Submission on Stage 2 State Significant Development Application (SSD-10294)

SYDNEY METRO VICTORIA CROSS PUBLIC DOMAIN GENERAL ARRANGEMENT PLAN SOUTHERN PORTAL -DENISON STREET

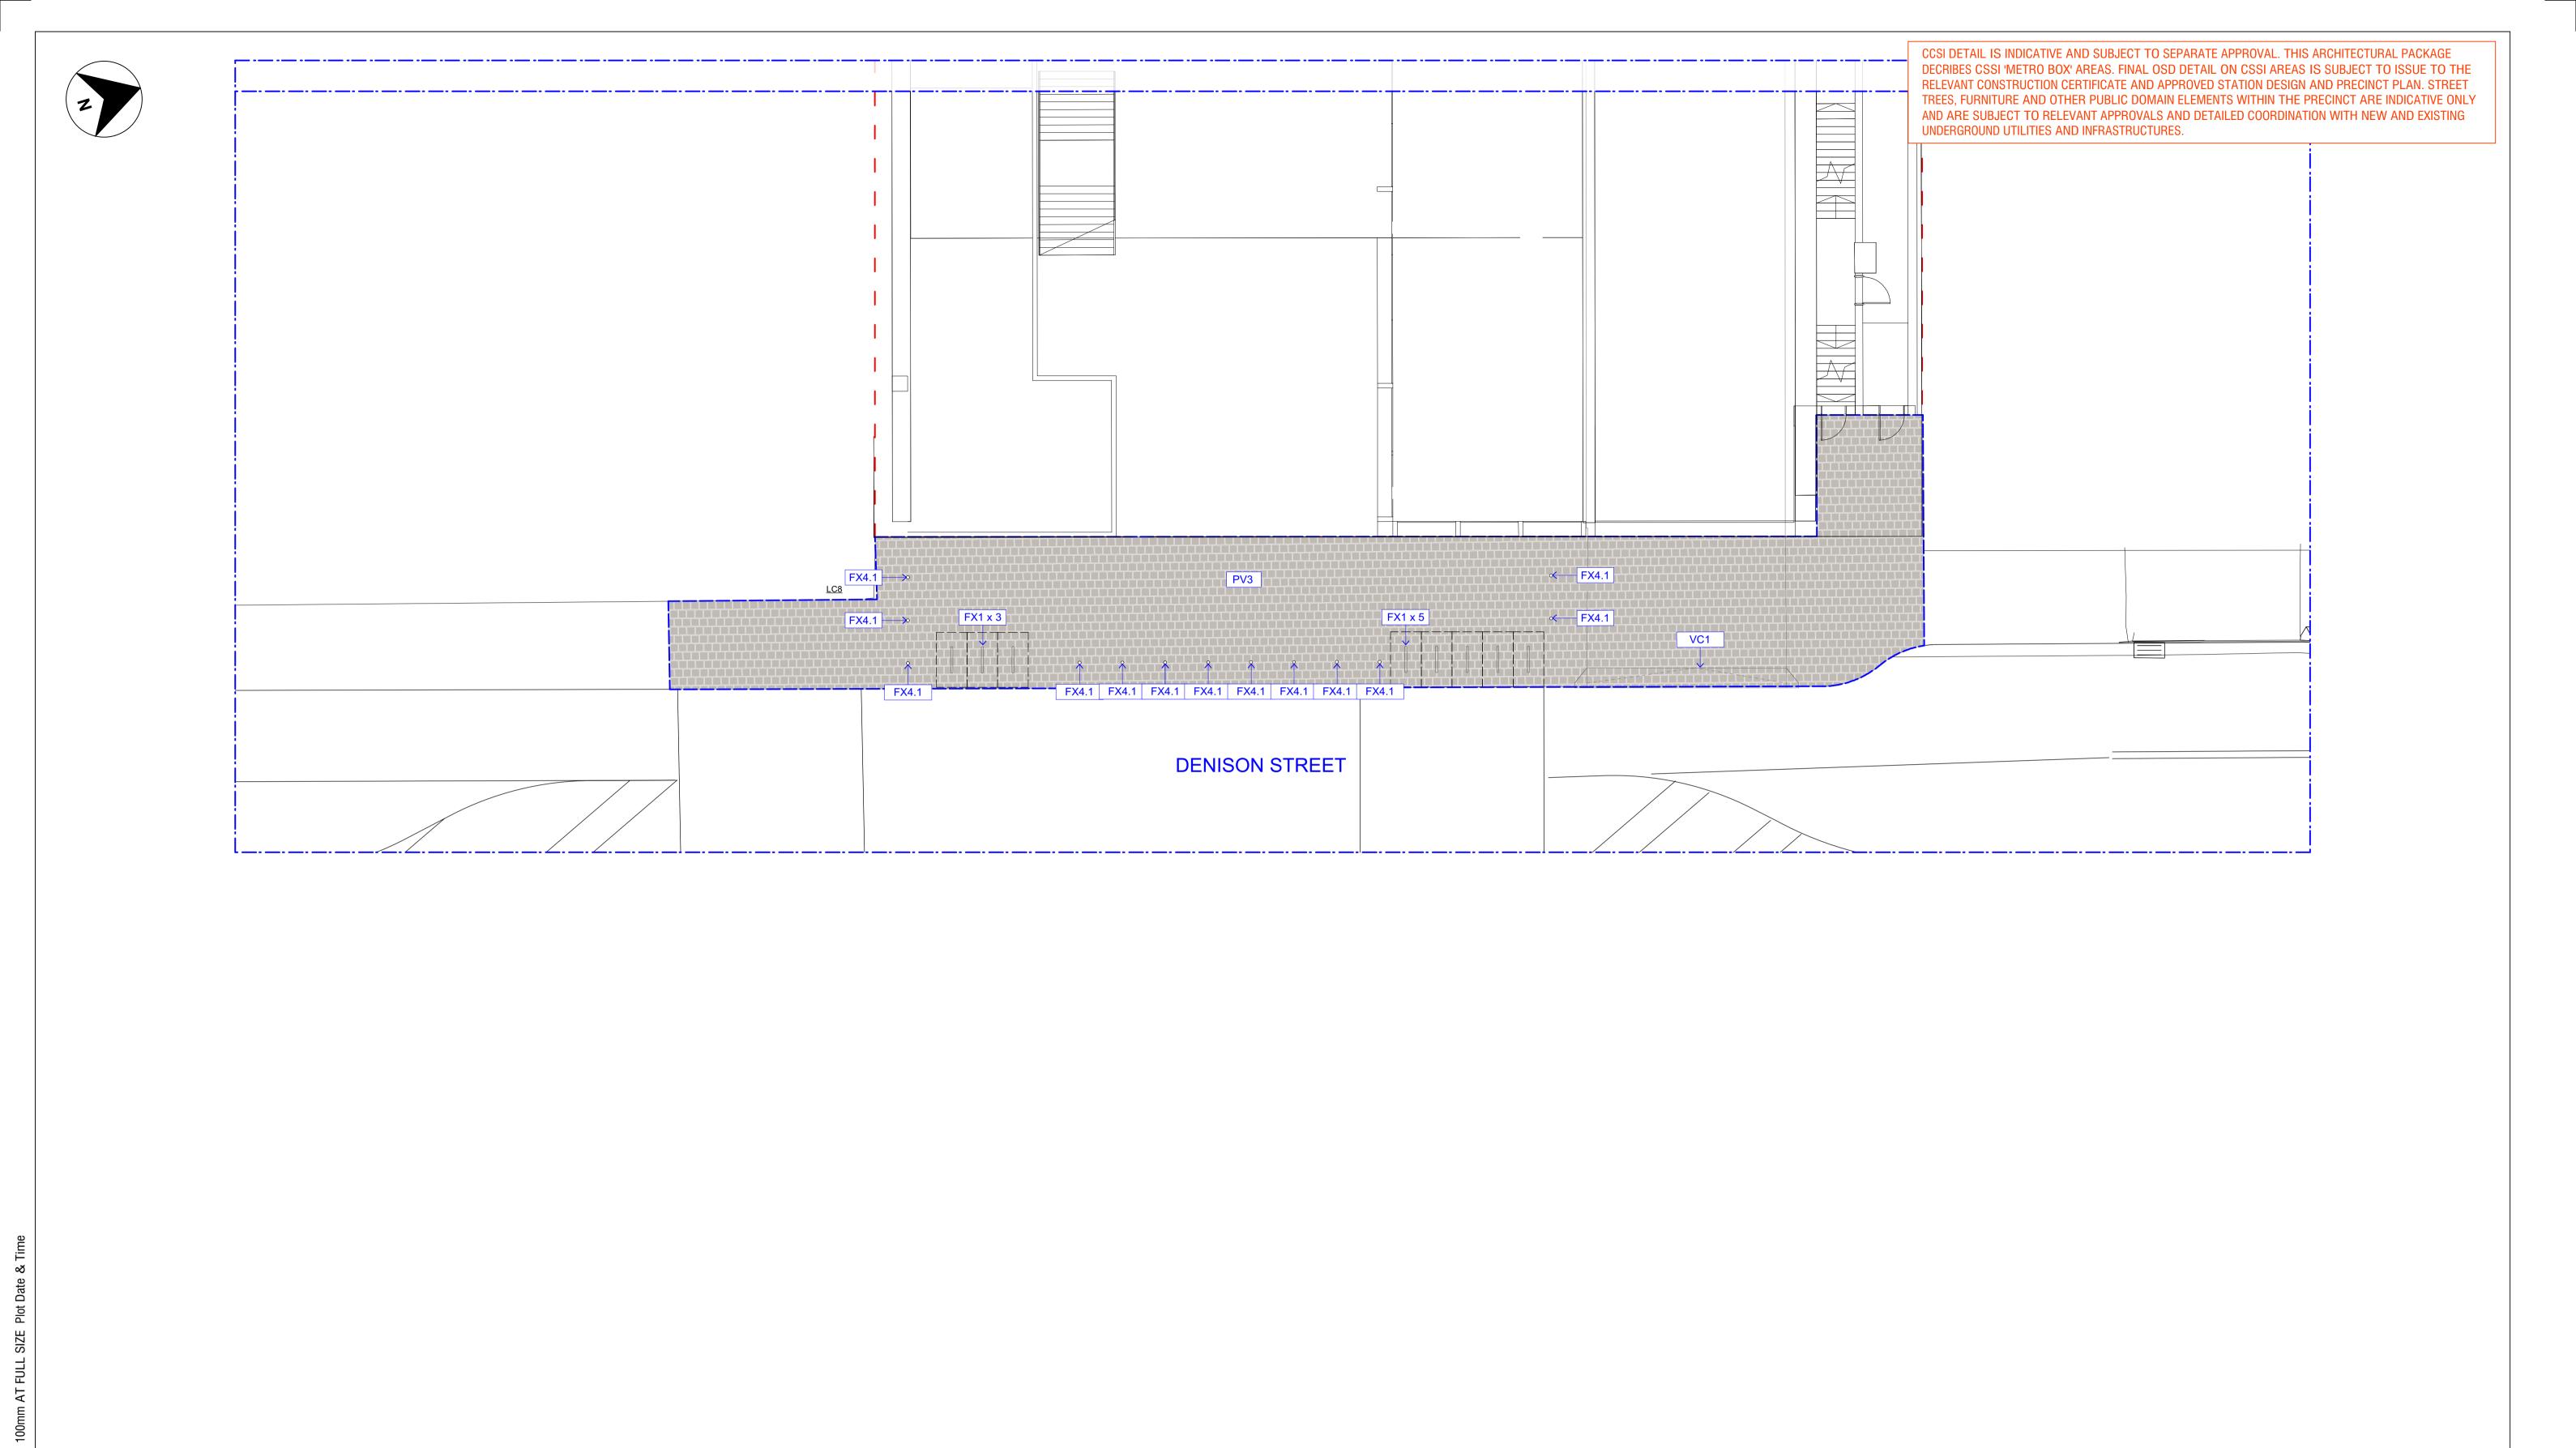
25. This plan offers a widened footpath area fronting Miller Street with only about 2m pedestrian paved area along the kerb of Miller Street which is completely inadequate for the current and future pedestrian traffic. The building setback is cluttered with raised grassed area and series of ramps and fenced outdoor platforms in front of the retail shops strictly privatising this very scarce and needed public space.

26. The suggested approach to public domain proposal for Miller Street frontage is considered unacceptable and bad urban design outcome for this hub of pedestrian activities in the CBD. The design should be maximising the circulation space and providing a flexible, level and generous plaza with shade trees and series of seats under trees fully integrating it with the Council’s proposed widening of the existing pedestrian area in Miller Street.

27. The public Domain Plan does not offer any information on how the buses and bus stops will integrate with the metro station and how commuters will flow from one mode of transport to the other.
